**Addendum No. 1**

RE: Contract # C204873

**Johnston County (I-5972)**

I-95 AND US-70 BUSINESS (MARKET STREET), EXIT 95 INTERCHANGE FROM  
OUTLET CENTER DRIVE TO WEST OF YELVERTON GROVE ROAD.

SHEET NO.
X-2

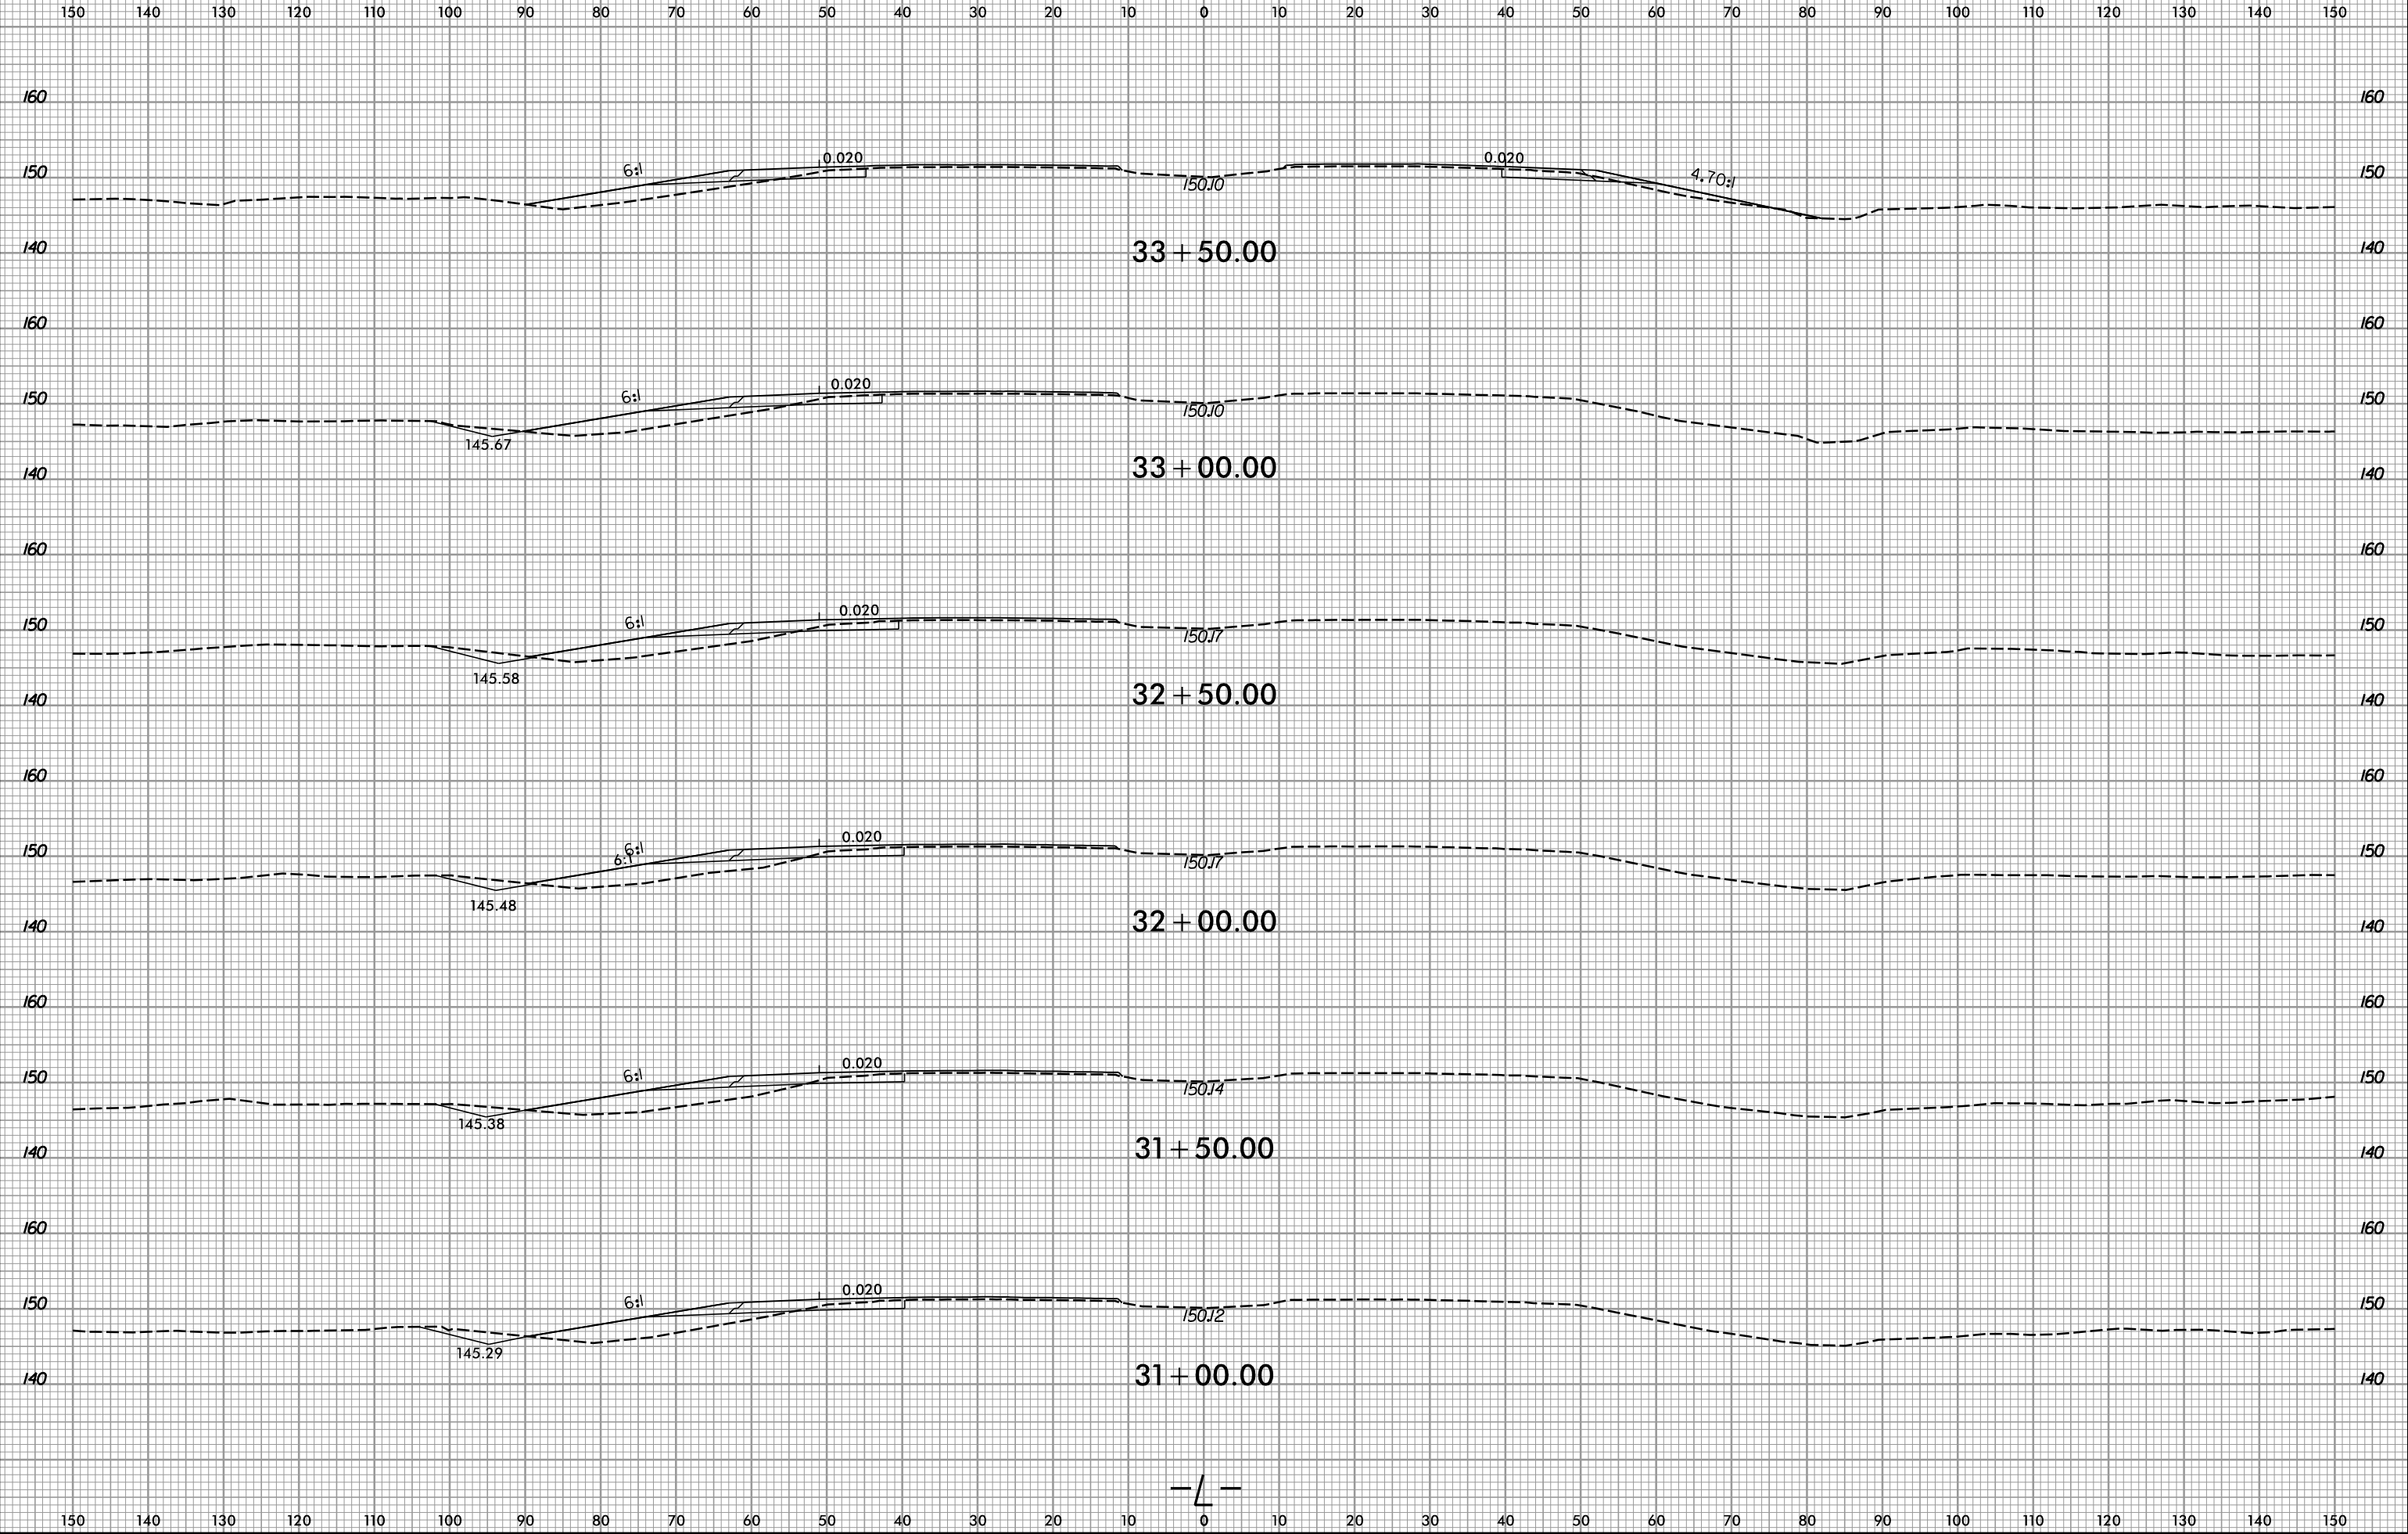
Sheet No.	Revision
X1-A, X-1 thru X-37	Cross Sections adjusted to the correct pavement thickness.
